# ENG-PUDSP22005-R1-GEC.pdf Markup Summary

PUDSP-22-005

**Subject:** Text Box  
**Page Index:** 1  
**Date:** 6/29/2022 11:22:59 AM  
**Author:** CDurham  
**Color:** ■  
**Layer:**  
**Space:**  
**Page Label:** [1] 21005234-GECP-Cover Sheet-COVER

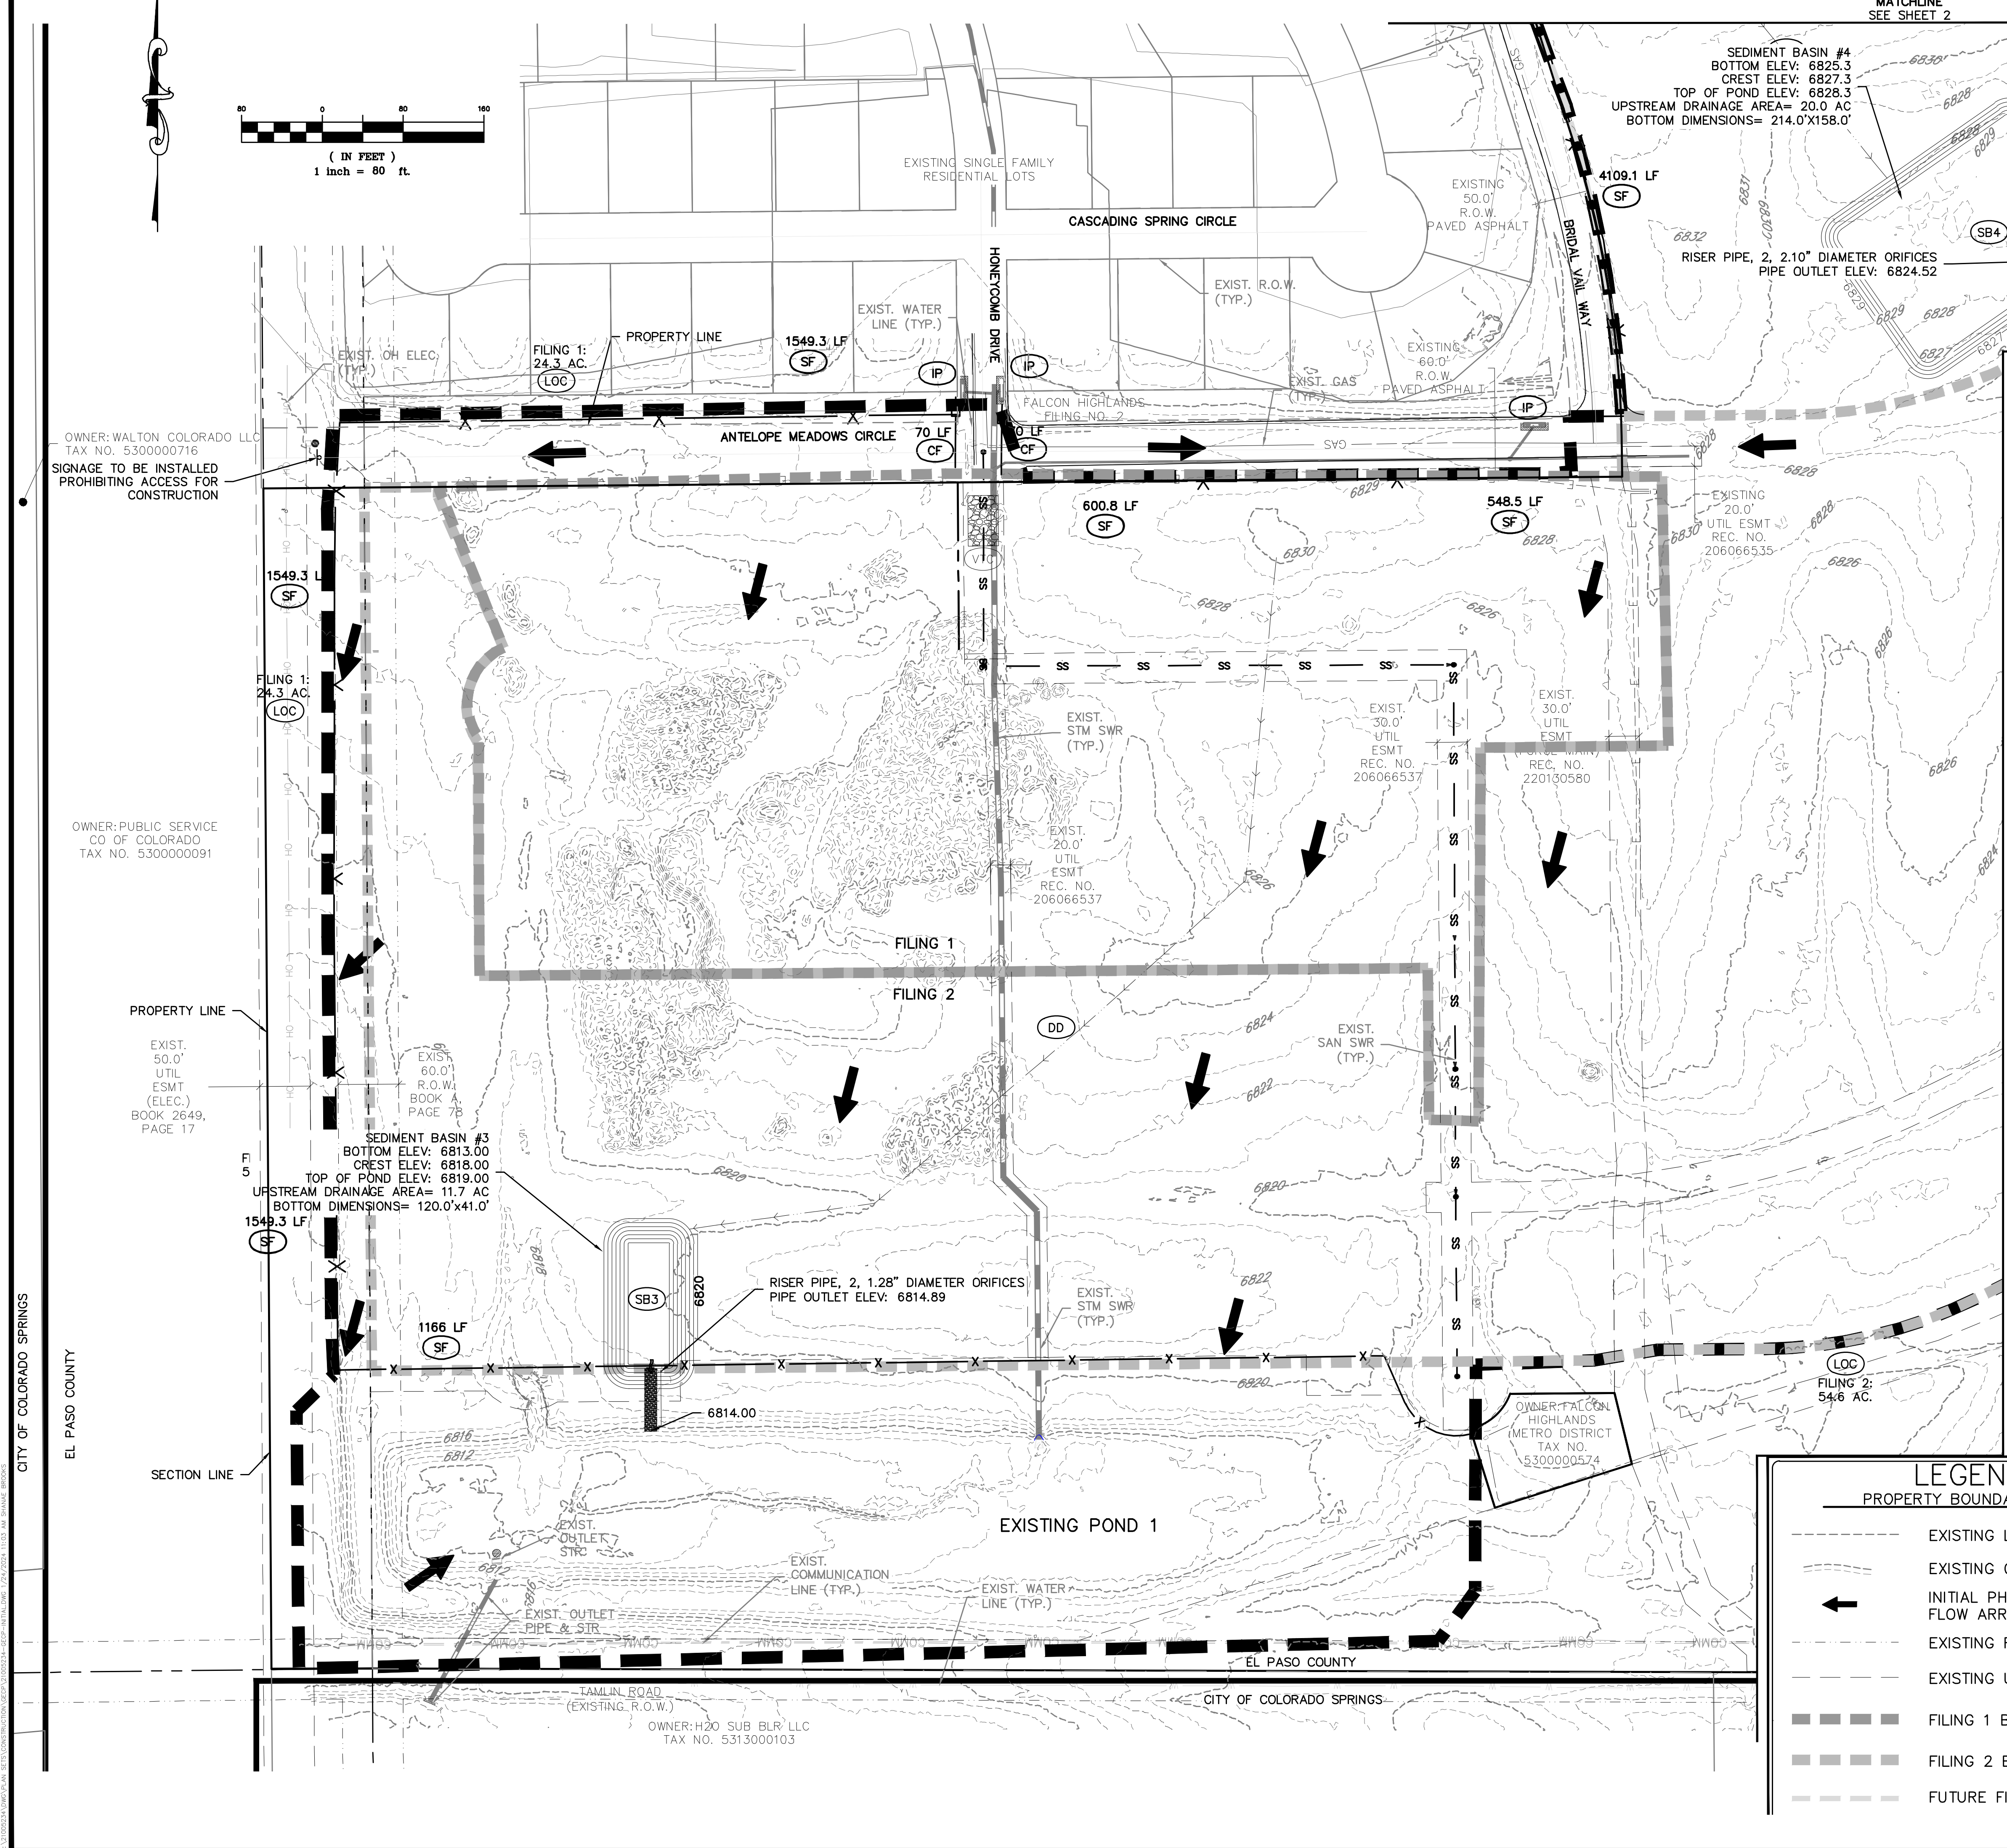
Please adjust shading, as I cannot tell between the two on the figures.

Item W. Provide construction fencing, barricades, and/or signage at access points not to be used for construction.

Include SF or other temporary BMPs to prevent sediment migration into the existing pond

4

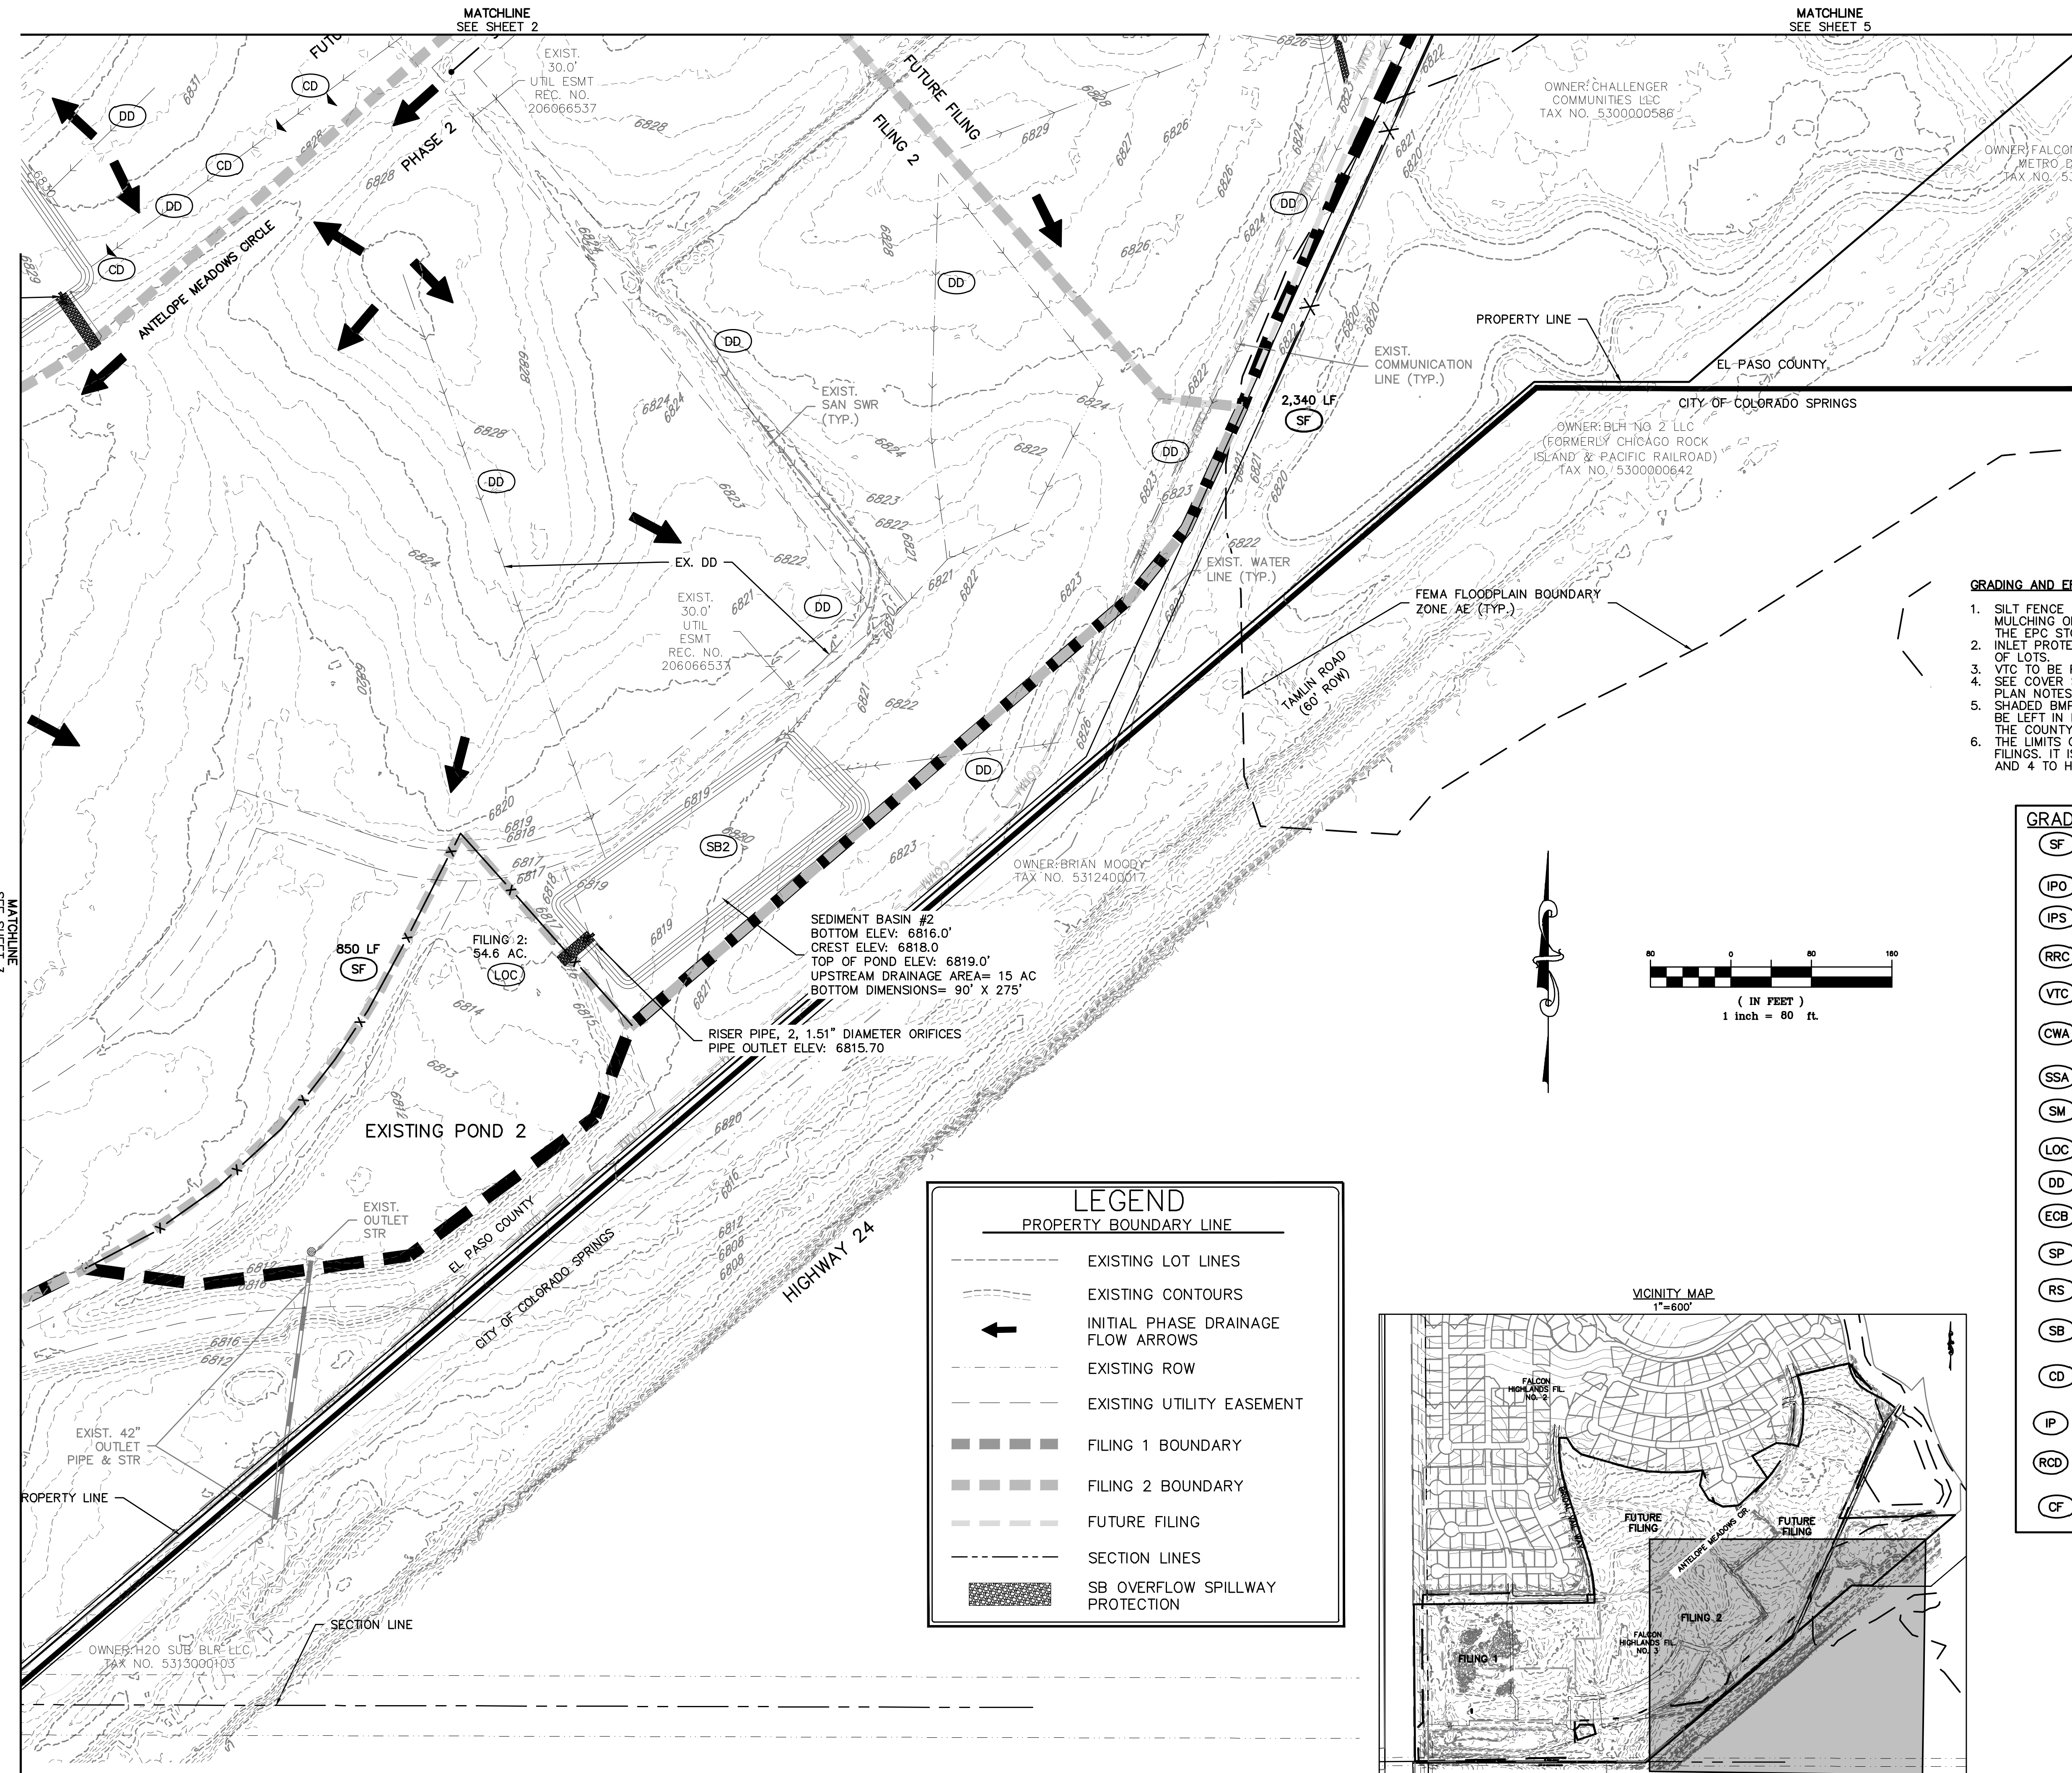
Revise hatched area to match sheet area (all sheets)

If this is part of a future phase, is there a reason why the TSB and DD need to be installed with this filing?

Include SF or other temporary BMPs to prevent sediment migration into the existing pond

JOB: 21005234 SHEET NO. 11

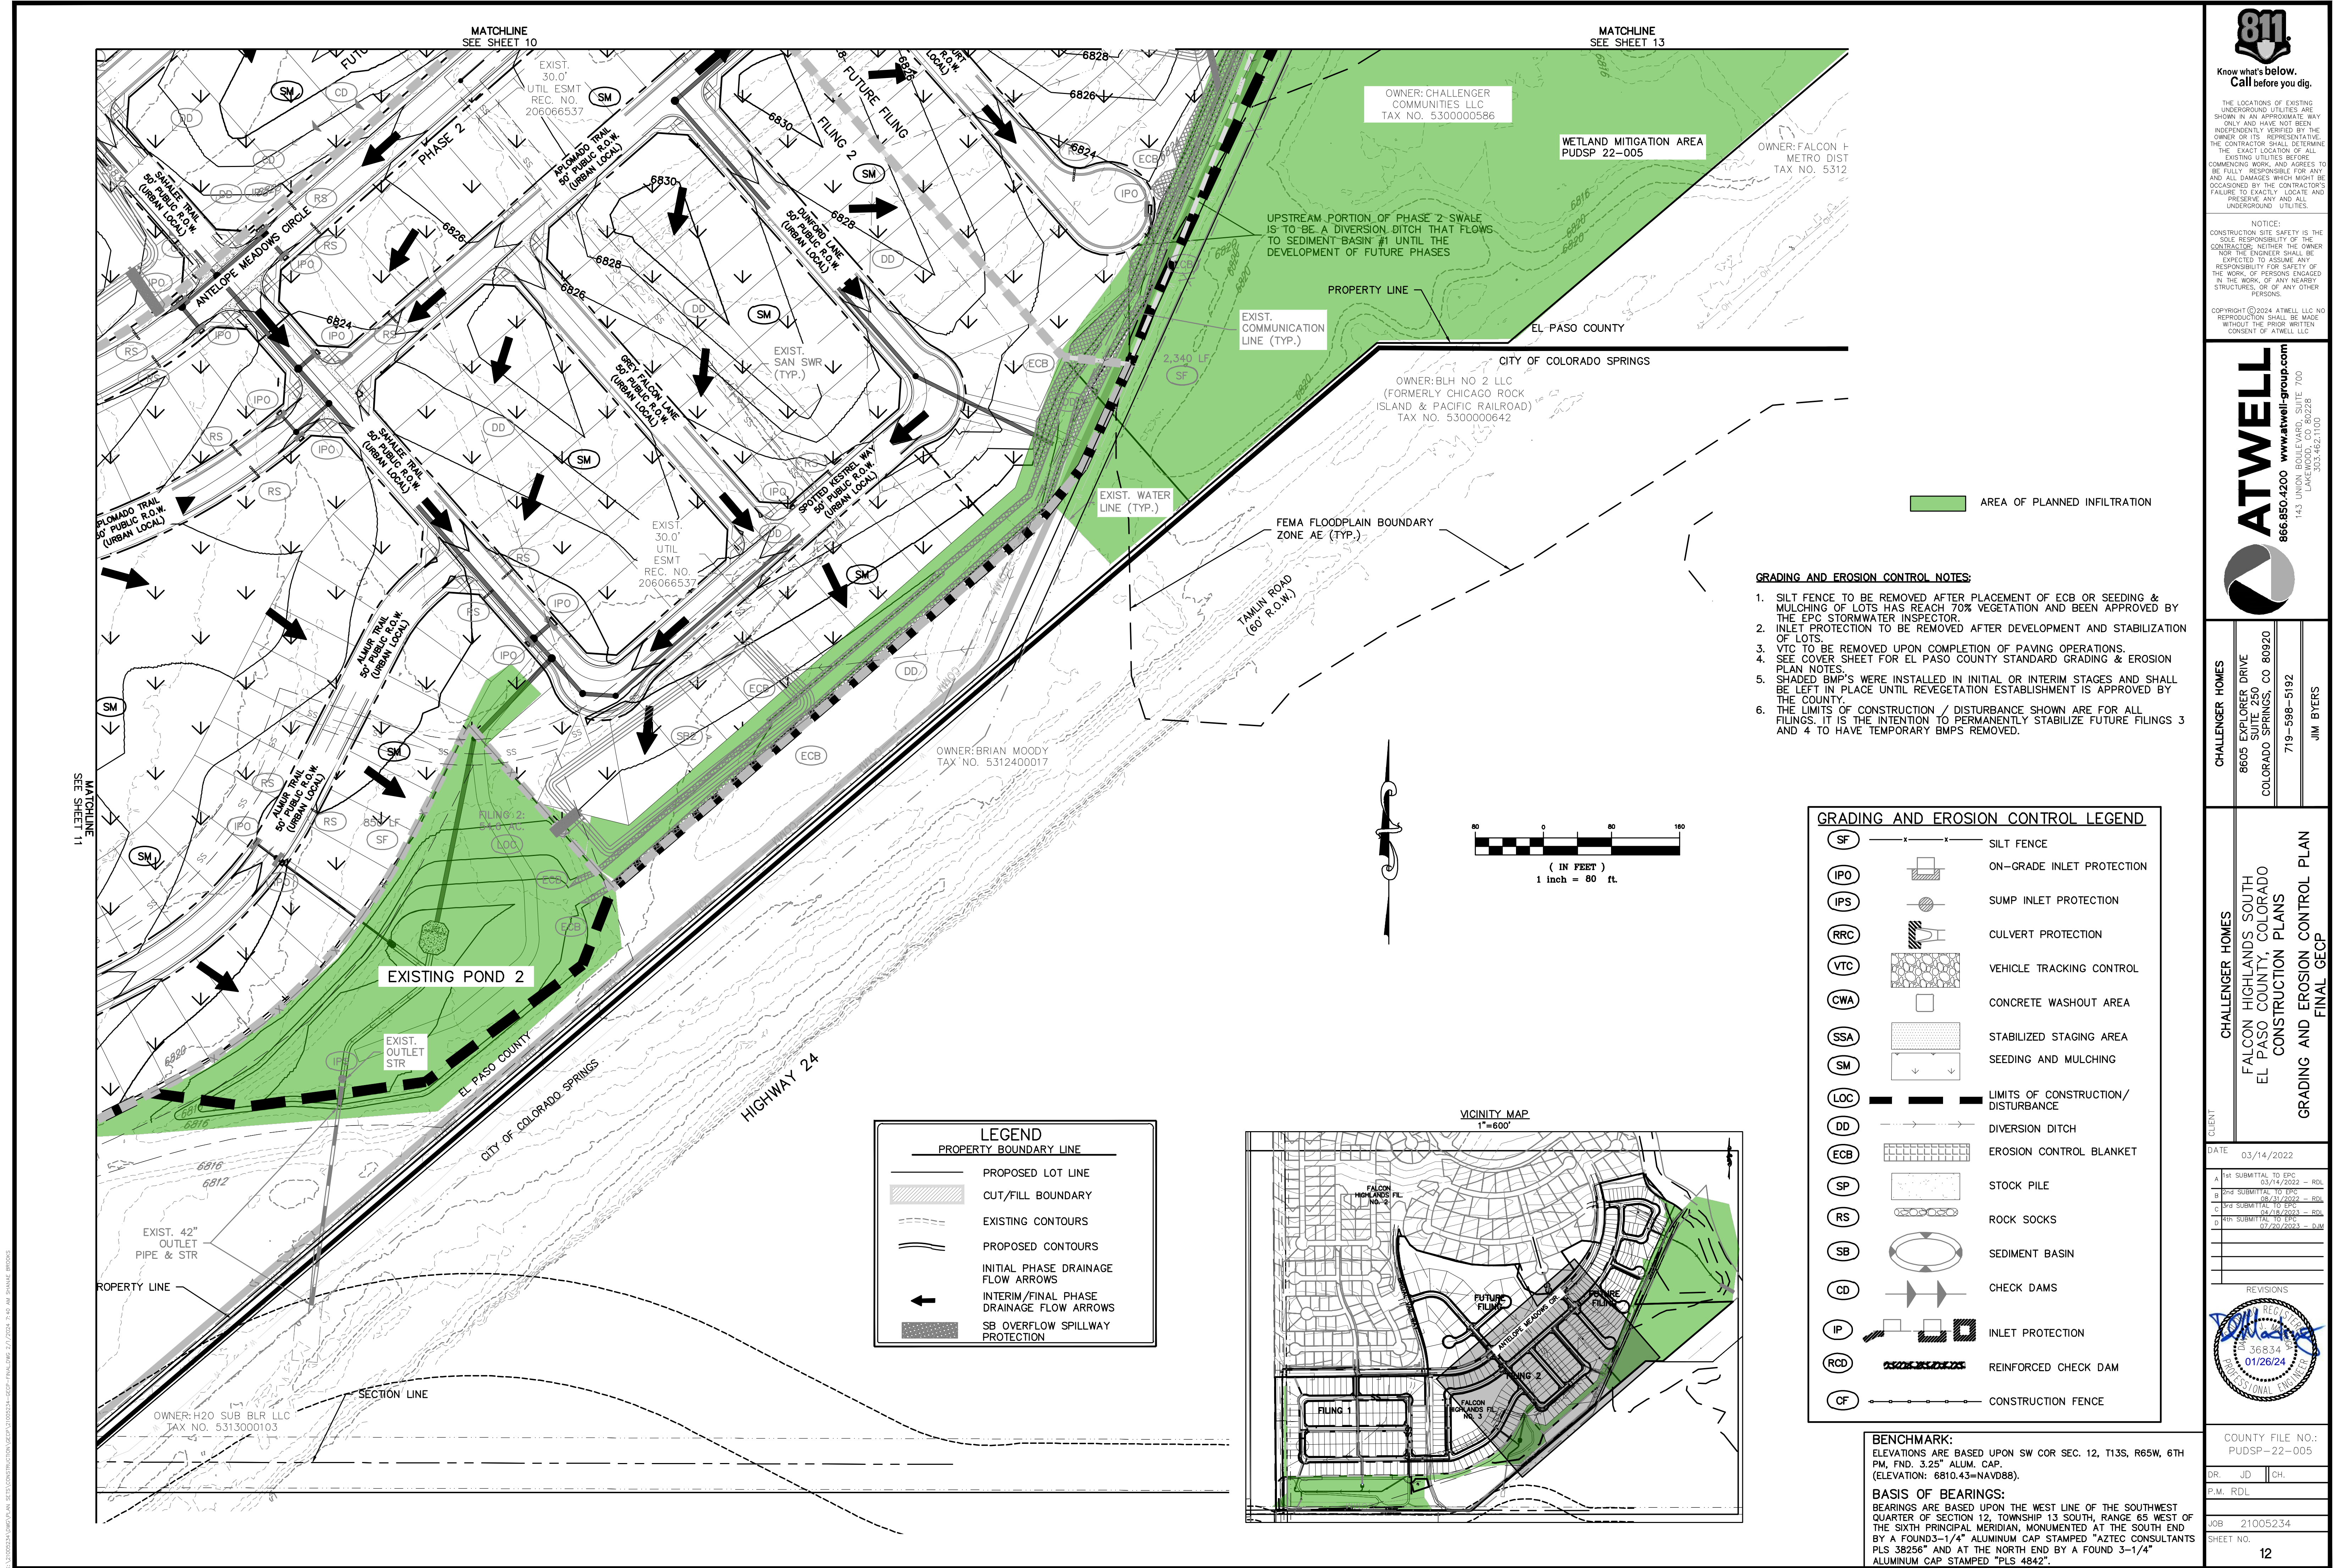
Update sheet #

Show and label existing Tamlin Road and ROW

show all proposed structures in pond
